Item No. **Report of the Head of Planning, Sport and Green Spaces**

Address 135 LONG LANE HILLINGDON

Development: Two storey side extension, single storey front and rear extension involving demolition of existing garage and installation of boundary wall to side

LBH Ref Nos: **24442/APP/2015/4639**

DRAWING TITLE:
PROPOSED GROUND
AND FIRST FLOOR
PLAN

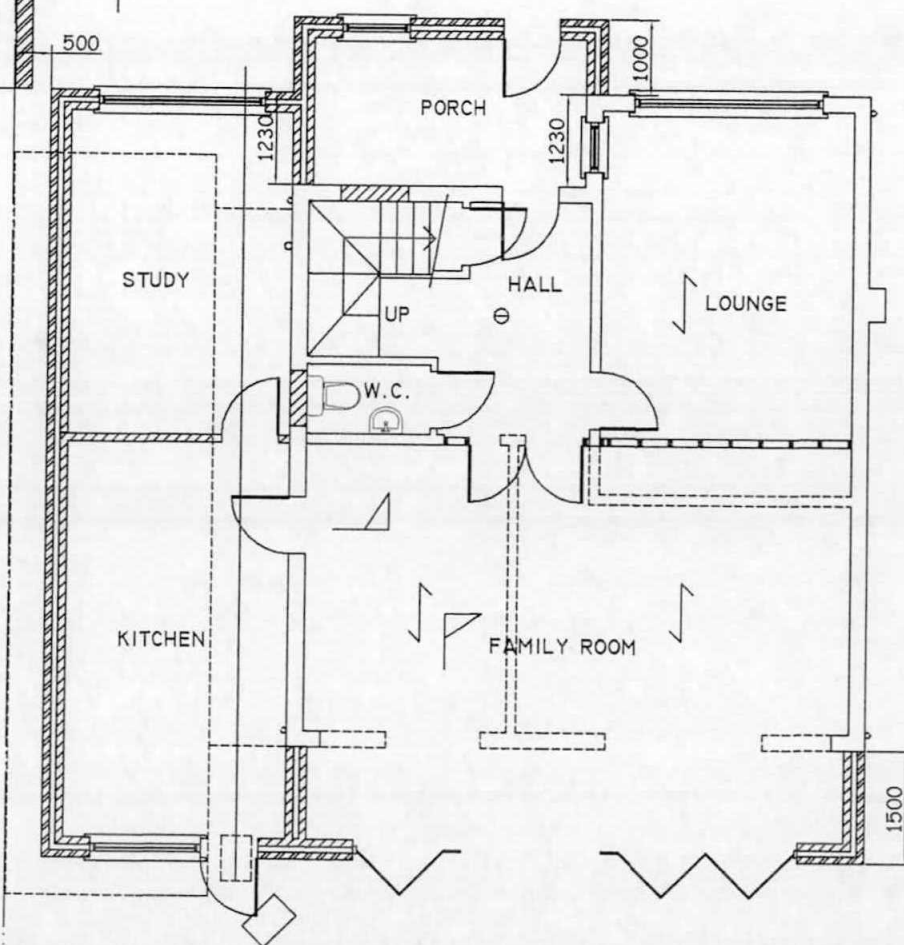
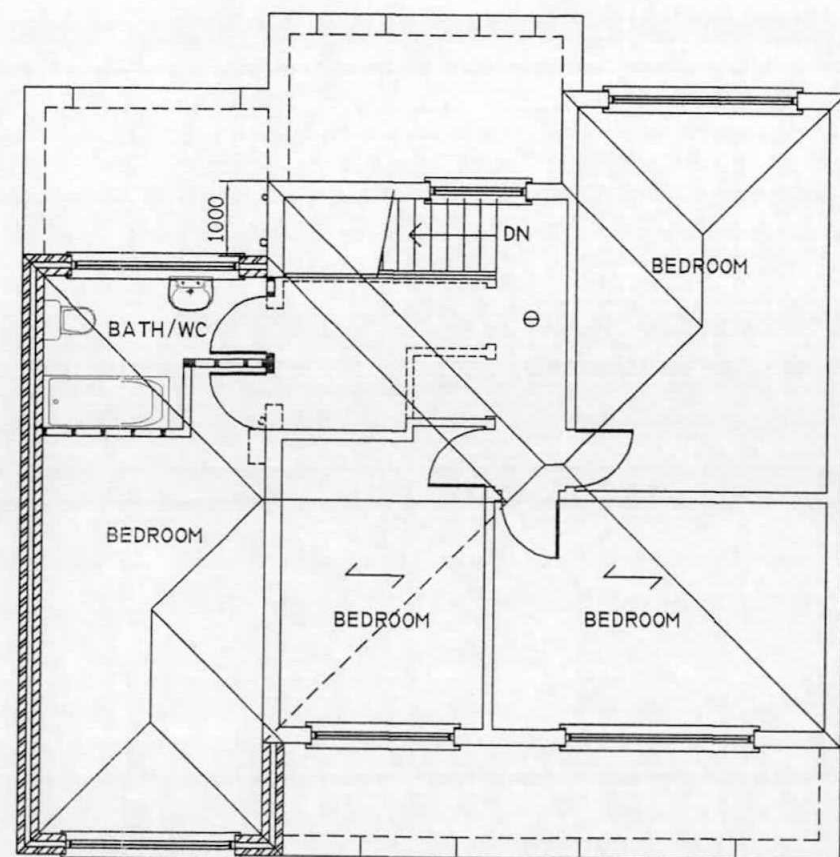
Guidance contained in paragraph 5.1 of the adopted HDAS SPD: Residential Extensions (December 2008). Paragraph 5.1 requires two storey side extensions to be set back a minimum of 1m from a side boundary for the full height of the building, so as to prevent gaps between properties and prevent houses from combining visually to form a terraced appearance. The proposed extension would not comply with this advice. The flank wall of the two storey side extension would be sited just 0.45m off the side boundary. Whilst it is accepted that an existing single storey structure is located alongside this side boundary, the significant increase in bulk, adjacent to the boundary would result in the loss of an important gap at first floor level between the application property and adjacent 135A Long Lane which would be detrimental to the spacing of development in the locality. As a result it is considered that it would have a negative impact upon the visual amenity of the site or the surrounding area in conflict with Policy BE1 of the Hillingdon Local Plan: Part One - Strategic Policies (November 2012) and policies BE13, BE15, BE19 and BE22 of the Hillingdon Local Plan: Part Two - Saved UDP Policies (November 2012).

The application includes the erection of a front porch which would measure 4.1m in width by 2.1m in depth with a ridge height of 3.38m. Section 8.0 of the HDAS SPD: Residential Extensions specifies that 'changes and extensions to the front of the house must be minor and not alter the overall appearance of the house or dominate the character of the street'. Section 8.1 of the HDAS gives advice that 'the Council is very explicit with regard to its position on front extensions. Front extensions that extend across the entire frontage will normally be refused. Front extensions are eye catching and change the face of the building. They do not only affect the character and appearance of the building itself, but also the streetscene'. Paragraph 8.2 of the HDAS gives advice that 'any porch should be individually designed to follow the character of the existing building. Porches should be subordinate in scale and form and should not be detrimental to the visual amenities of the street scene. The roof design and the roof material must match the main roof'. The ridge of the proposed porch would extend to the cill height of the first floor window above and in view of its significant scale is considered to detract from the architectural integrity of the host dwelling. It is considered that the design and size of the enlarged porch at the front are such that it would be detrimental to the character and appearance of the property, the streetscene and the visual amenities of the wider area, contrary to the requirements of Policies BE13, BE15 and BE19 of the Hillingdon Local Plan: Part Two - Saved UDP Policies (November 2012) and HDAS SPD: Residential Extension

In terms of the garden area at least 100m² of rear private garden should be retained to provide adequate amenity space for a four bedroom dwelling. The resultant amenity space would be just 64m² which would fail to meet the HDAS requirement. The proposal would therefore be contrary to Policy BE23 of the Hillingdon Local Plan Part 2.

Saved policy BE38 seeks the retention and utilisation of topographical and landscape features of merit and the provision of new planting and landscaping wherever it is appropriate. There are 2 No. mature oak trees along the front boundary of the site which dominate the front garden which form a long line of Oak trees along Long Lane which are important in terms of the visual amenity of locality. The proposal includes a brick wall measuring 2m in height to the side of the driveway in close proximity to these oak trees. The applicant has failed to submit a tree survey and arboricultural impact assessment, to BS2012:5837 to demonstrate that the protected trees will be unaffected by the development and has not made provision for their long-term protection. As such the proposal is contrary to Policy BE38 of the Hillingdon Local Plan - Saved UDP Policies (November 2012).

The proposed two storey side/rear extension, by reason of its size, scale, bulk and proximity to the side boundary, would result in a closing of the visually open gap between it and the neighbouring property, 135A Long Lane, giving rise to a cramped form of development and possible terracing effect, which would be detrimental to the visual amenities of the street scene and the surrounding area generally. The proposal is therefore contrary to Policy BE1 of the Hillingdon Local Plan: Part One - Strategic Policies (November 2012), Policies BE13, BE15, BE19 and BE22 of the Hillingdon Local Plan: Part Two - Saved UDP Policies (November 2012) and the adopted Supplementary Planning Document HDAS: Residential Extensions.

The proposed front porch/front extension, by virtue of its size, scale, design and projection forward, would result in an incongruous and overly dominant addition which would be detrimental to the architectural composition of the existing building and to the visual amenities of the street scene and the surrounding area generally. The proposal is therefore contrary to Policy BE1 of the Hillingdon Local Plan: Part One - Strategic

In the absence of a tree survey and arboricultural impact assessment, to BS2012:5837, the applicant has failed to demonstrate that the protected Oak trees along the front boundary of the site will be unaffected by the development and has not made provision for their long-term protection. The proposal is therefore detrimental to the visual amenities of the street scene and the surrounding area generally. The proposal is therefore contrary to Policies BE13, BE19 and BE38 of the Hillingdon Local Plan: Part Two - Saved UDP Policies (November 2012).

The proposed extensions would, by virtue of their failure to maintain an adequate amount of private usable external amenity space for the occupiers of the existing property, result in over-development of the site detrimental to the residential amenity of existing and future occupiers. The proposal is therefore contrary to policies BE19 and BE23 of the Hillingdon Local Plan - Saved UDP Policies (November 2012) and the guidance contained within the Hillingdon Design and Accessibility Statement Supplementary Planning Document: Residential Extensions (December 2008).
